9 December 2015

Department of Planning and Environment
GPO Box 39
SYDNEY NSW 2001

**WAREHOUSE AND DISTRIBUTION CENTRE (NOTICE OF EXHIBITION)
2 HUME HIGHWAY & 12 HUME HIGHWAY, CHULLORA (SSD 7235)**

Site Plan

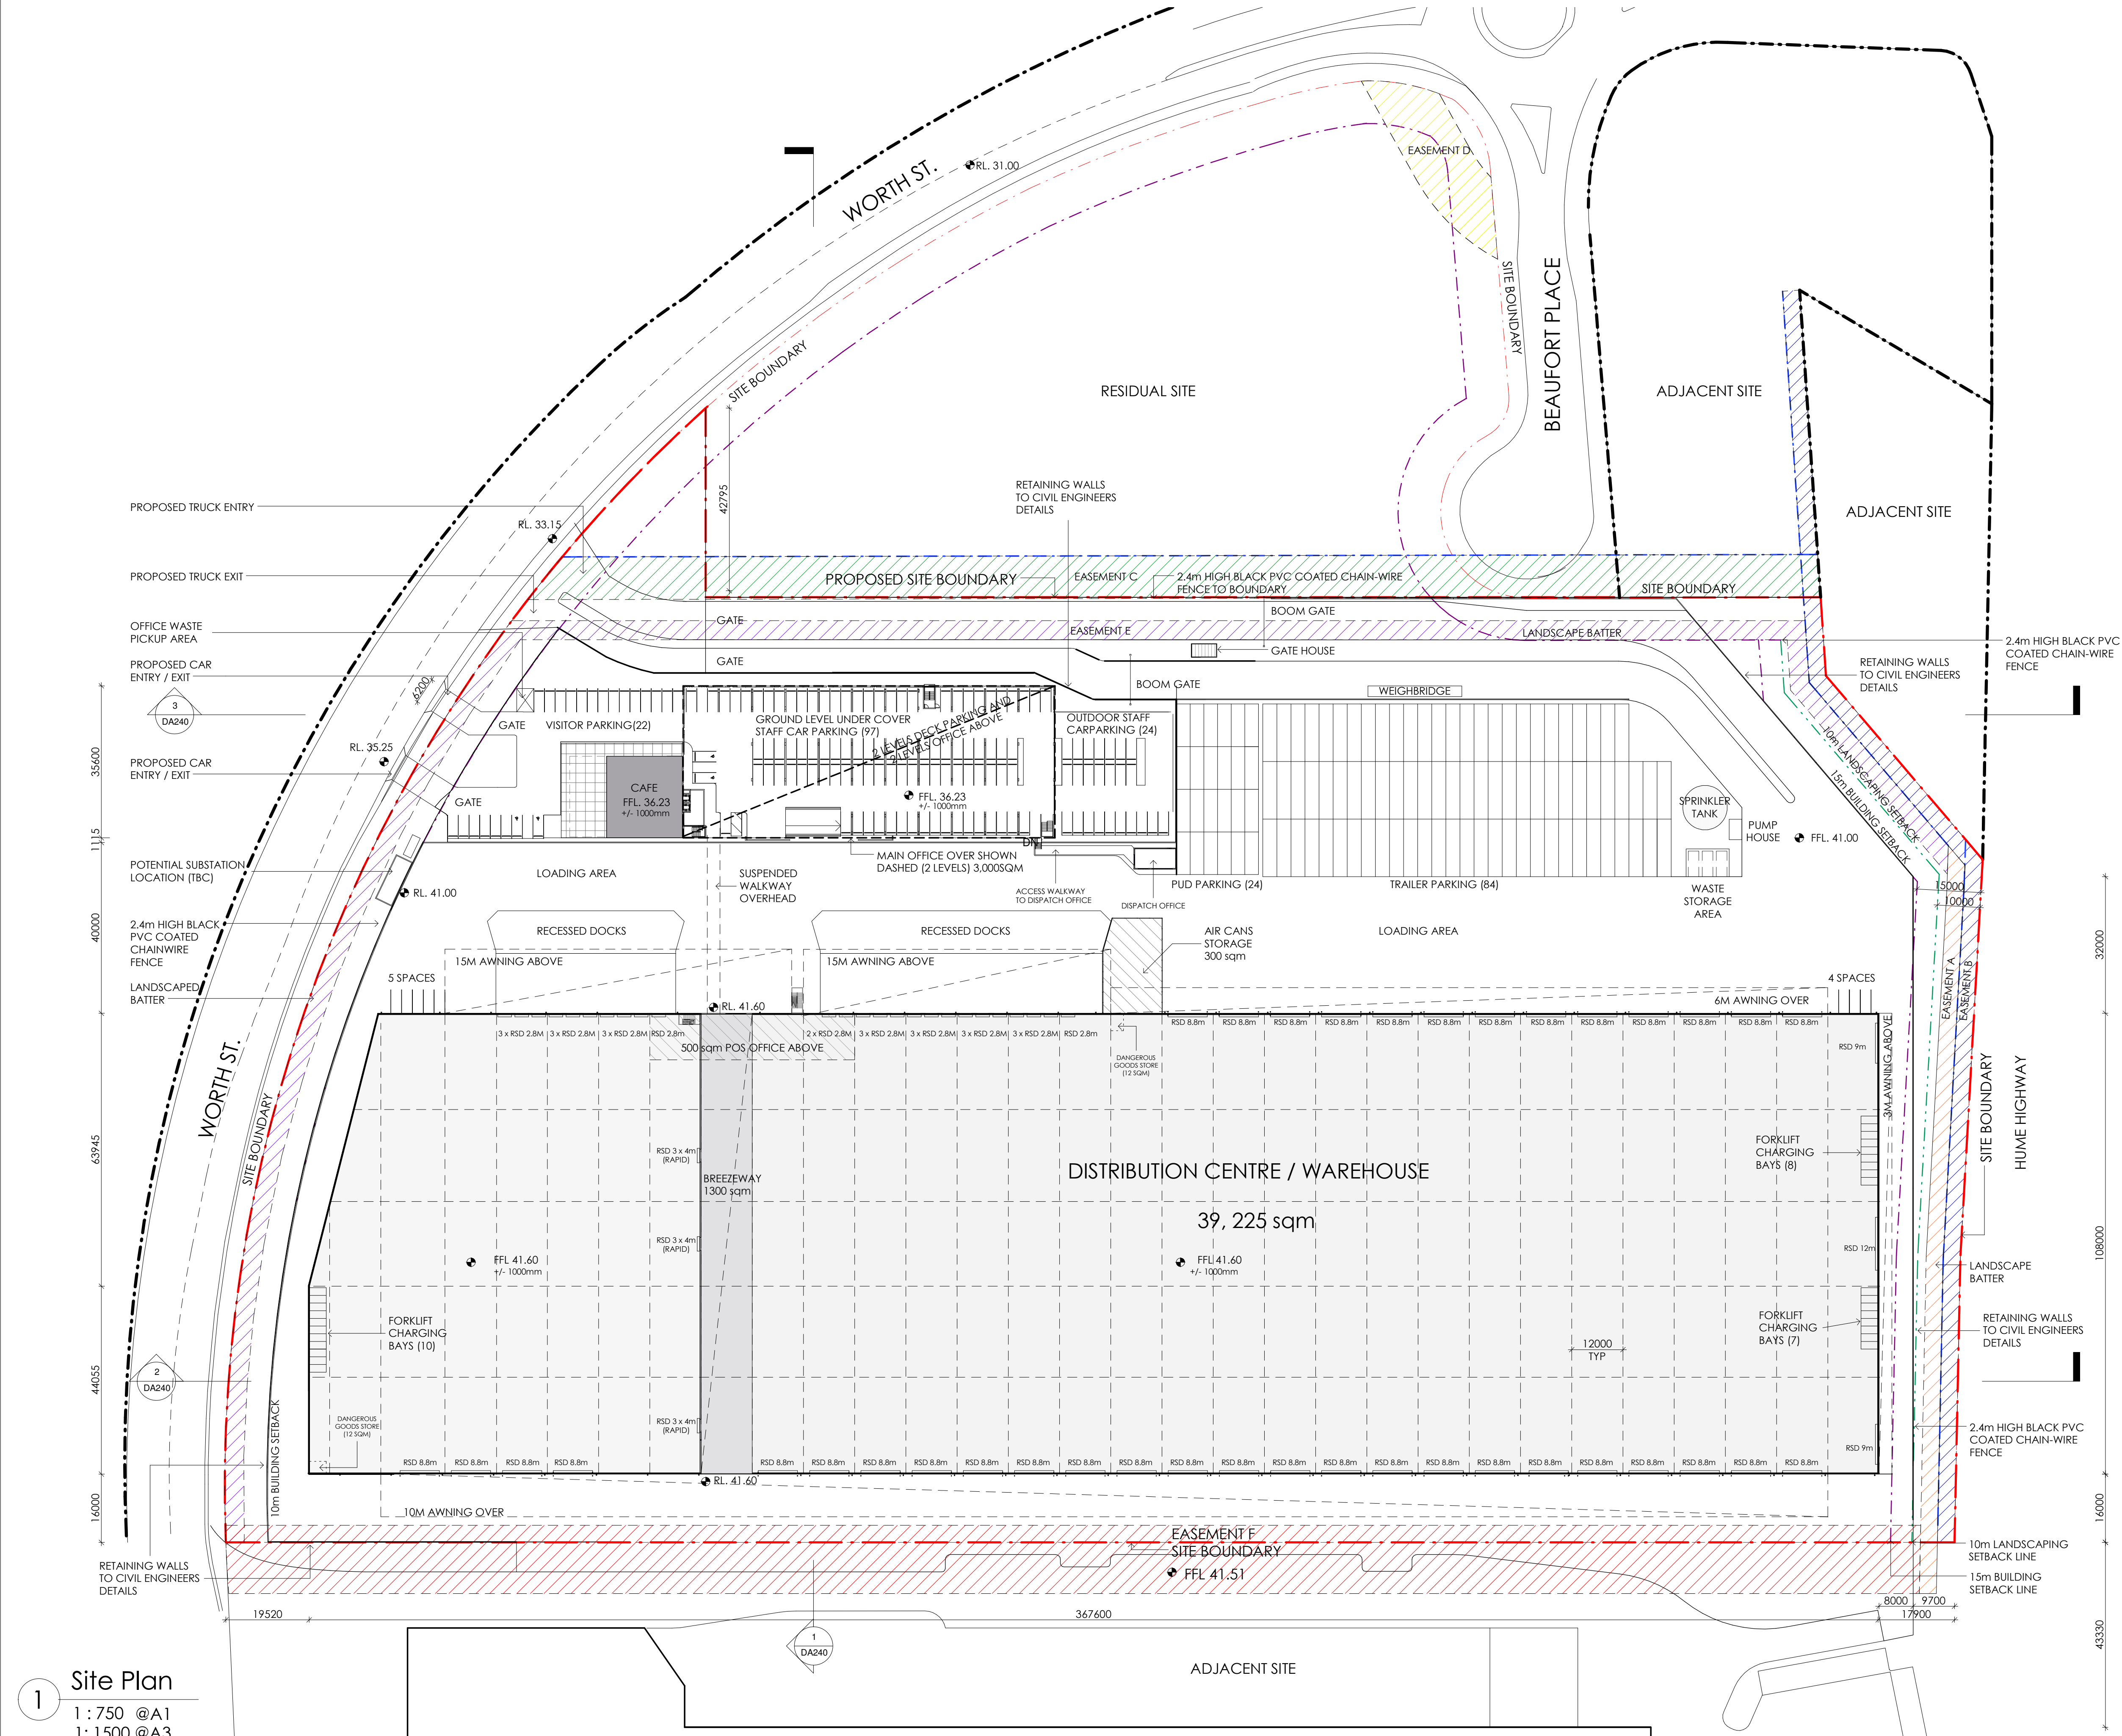
- It is noted that some 352 on site car parking spaces are proposed. However, no comment has been made in relation to truck parking bays or any temporary truck standing areas; and
